Application No: P/147/21/RES
Site Address: Land adjacent to Sefter School House Sefter Road Bognor Regis PO21 3EE
Description of works: Approval of reserved matters following P/116/19/OUT for 4 No semi detached 3 bed & 2 No detached 4-bed dwellings with associated access, parking & gardens (resubmission following P/111/21/RES). This site is in CIL Zone 5 and is CIL Liable as new dwellings.

Thank you for your internet representation made on 27th October 2021 which has been recorded as an objection with the comments as follows:

Re: P/147/21/RES - Land adjacent to Sefter School House, Sefter Road, Bognor Regis PO21 3EE

Project
Land adjacent to Seftor School House
Seftor Road
Bignor Regis
PO21 3EE
Drawing Title
Plot 1
Elevations

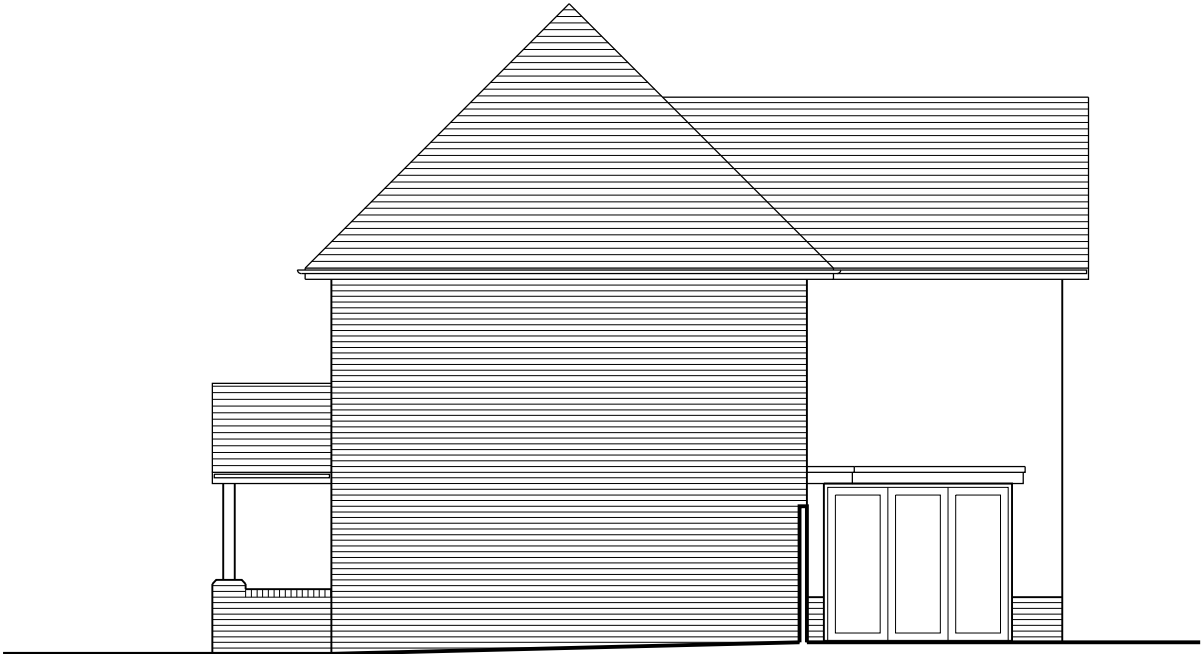
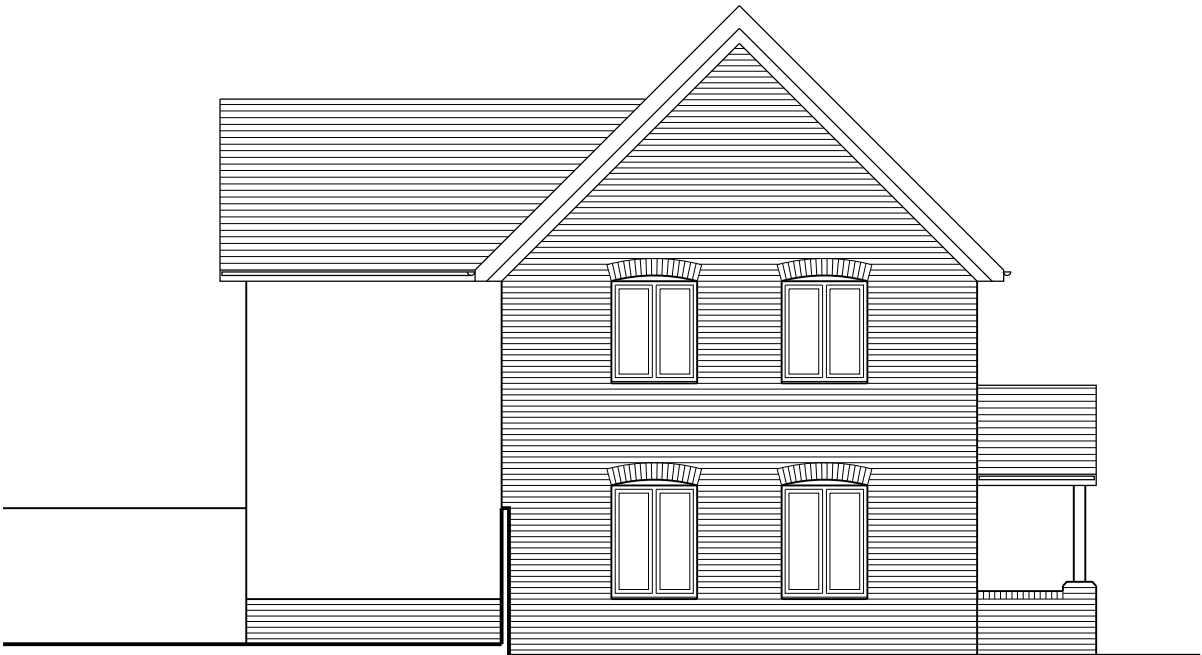
It would appear that there is nothing in this application that mitigates the proposed use of non-traditional building materials that conflict with the traditionally built surrounding properties at Sefter School House, Sefter Cottage and Rookery Cottage. As such, this proposal continues not to accord with the Design Code Q.01 Rural Development

Project
Land adjacent to Sefter School House
Sefter Road
Bignor Regis
PO21 3EE
Drawing Title
Site Elevations and Massing Views

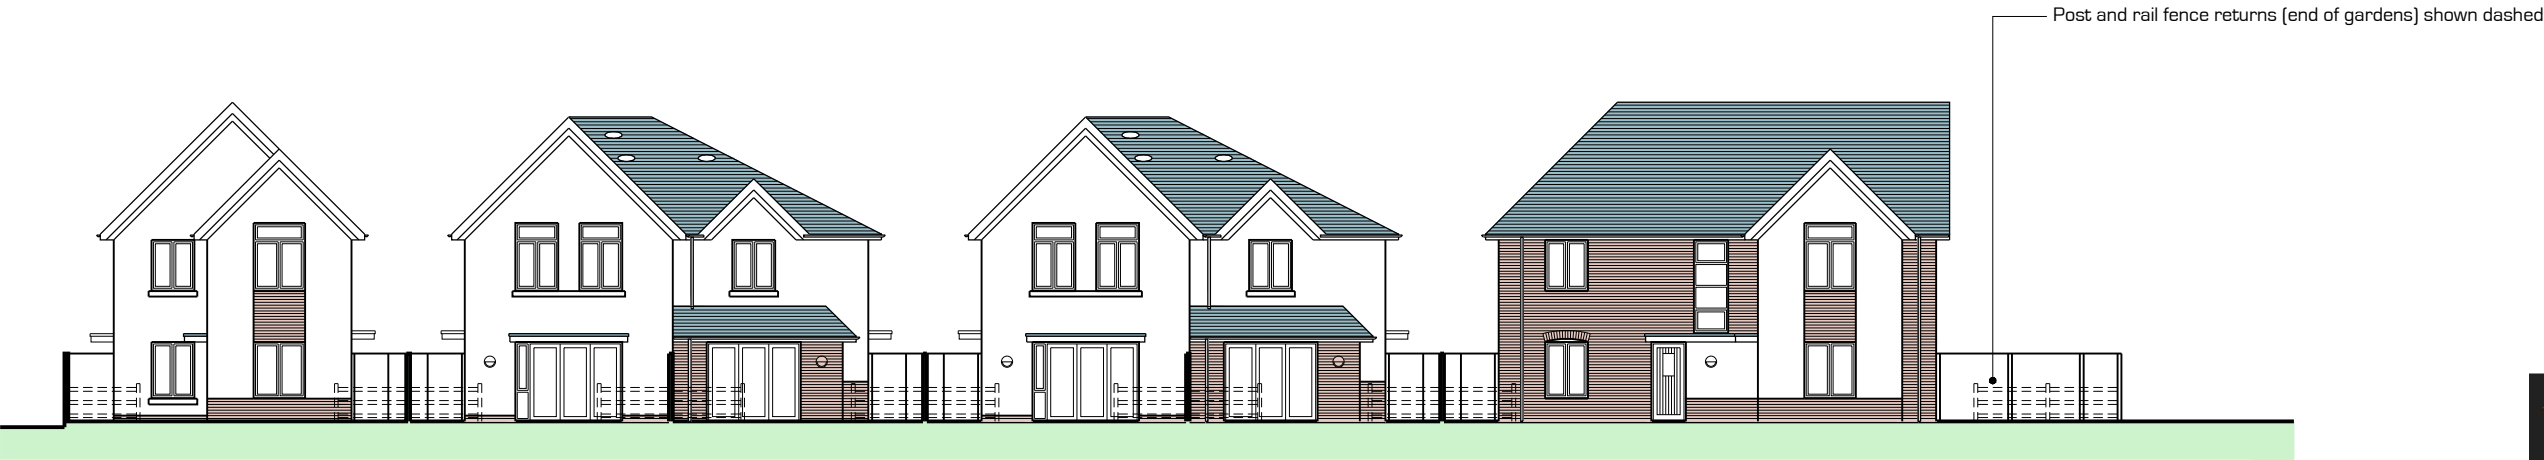
In my objection to P/111/21/RES, I highlighted the fact the elevation of the applicant's land adjacent to our boundary is approximately 2 metres higher than our own land. As a consequence, the proposed houses will, at ground-floor level, overlook the garden and patio of Sefter Cottage with a resulting loss of privacy and amenity. Nothing in this application addresses the issue of loss of privacy.
